**Town & Country Planning Act 1990 (as amended)
Town & Country Planning (Development Management Procedure) (England) Order 2015
Application for Planning Permission for Works or Extension to a Dwelling**

Development Retention of car port to side elevation & raised roof to existing garage.

Location 9 Arundel Road Poling

Existing Ground Floor

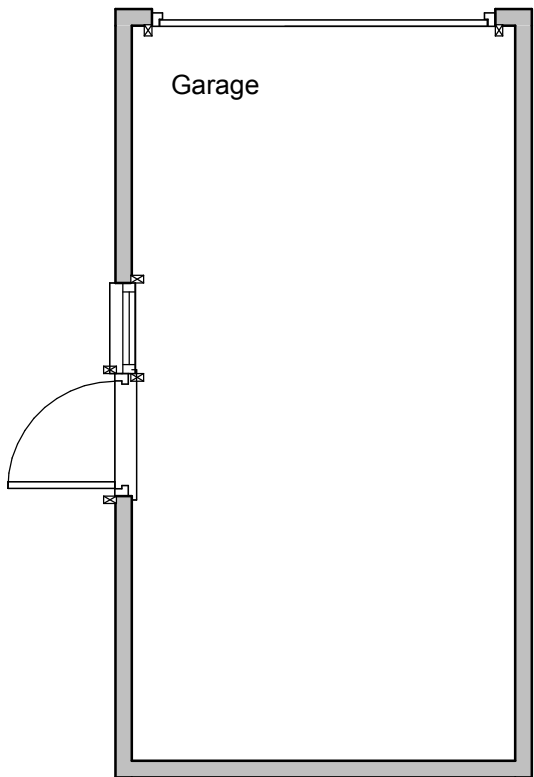
Existing floor plan and elevations:

Please remove the reference to the car port on the floor plan.

Please show the windows on the east floor plan to match the windows on the east elevation.

Site Plan 1:500

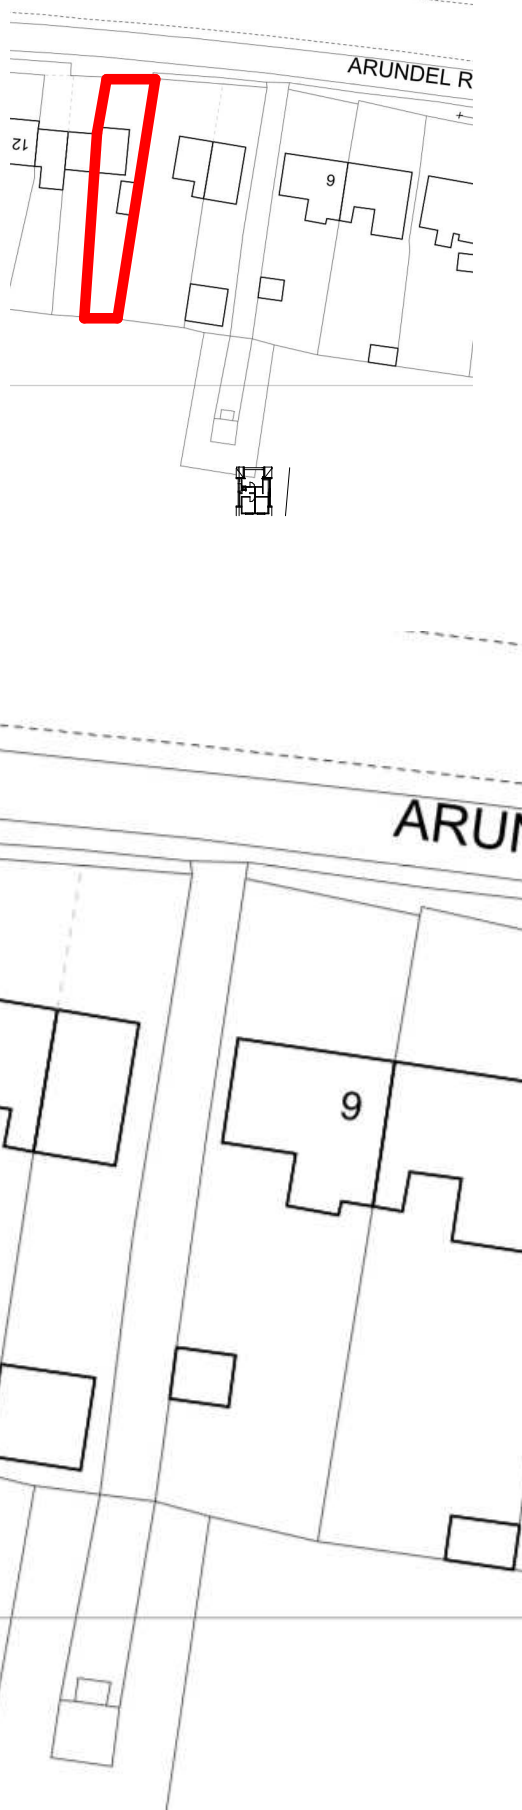
Block Plan Amend

Please show the car port.

Existing Roof Plan

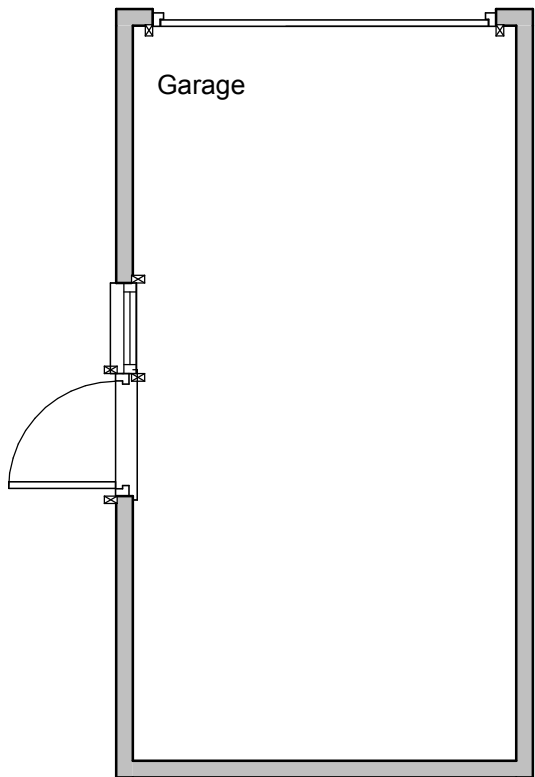
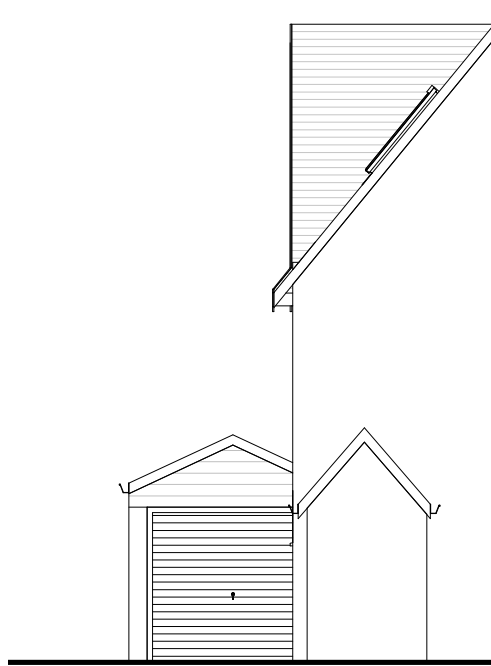
Roof Plans for the garage

Please submit 1 electronic or 3 paper copies of existing and proposed roof plan. Please refer to the Validation Requirements List for further details.

Existing Side Elevation East

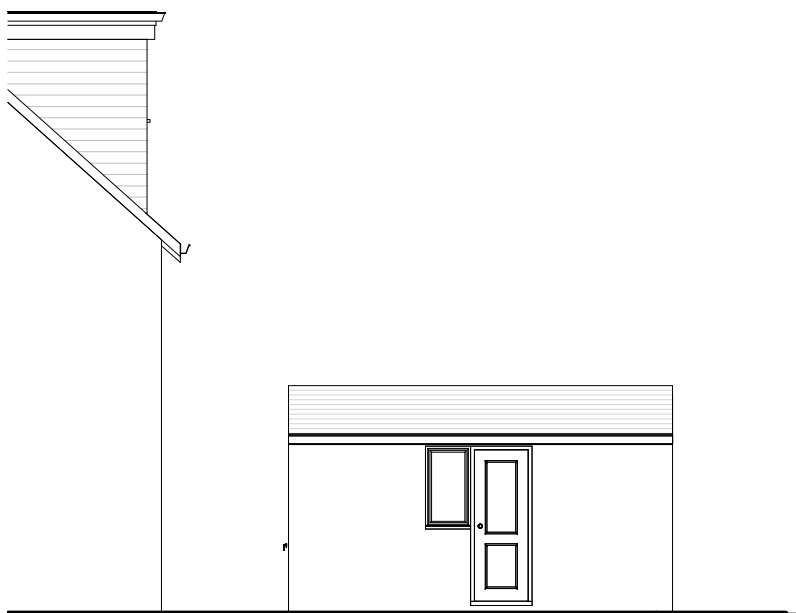
Please remove the car port from the east elevation.

Please show the roof on the garage before it was raised.

Proposed Side Elevation East

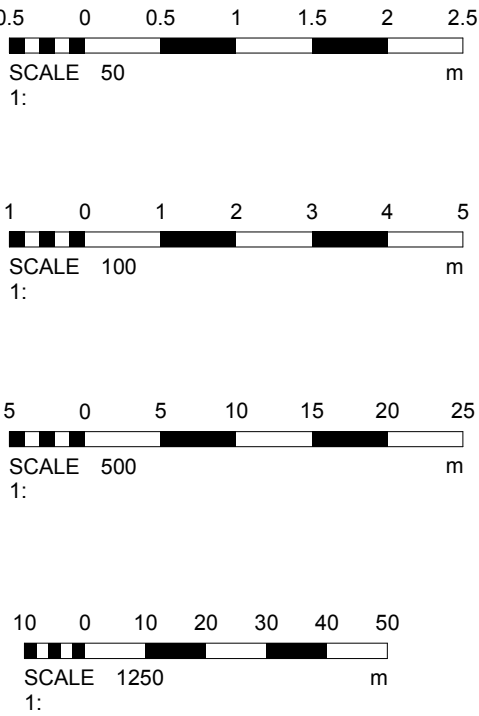
Proposed floor plan and elevations:

Please show the carport and windows on the floor plan to match the east elevation.

Please show the garage with the raised roof on the elevations.
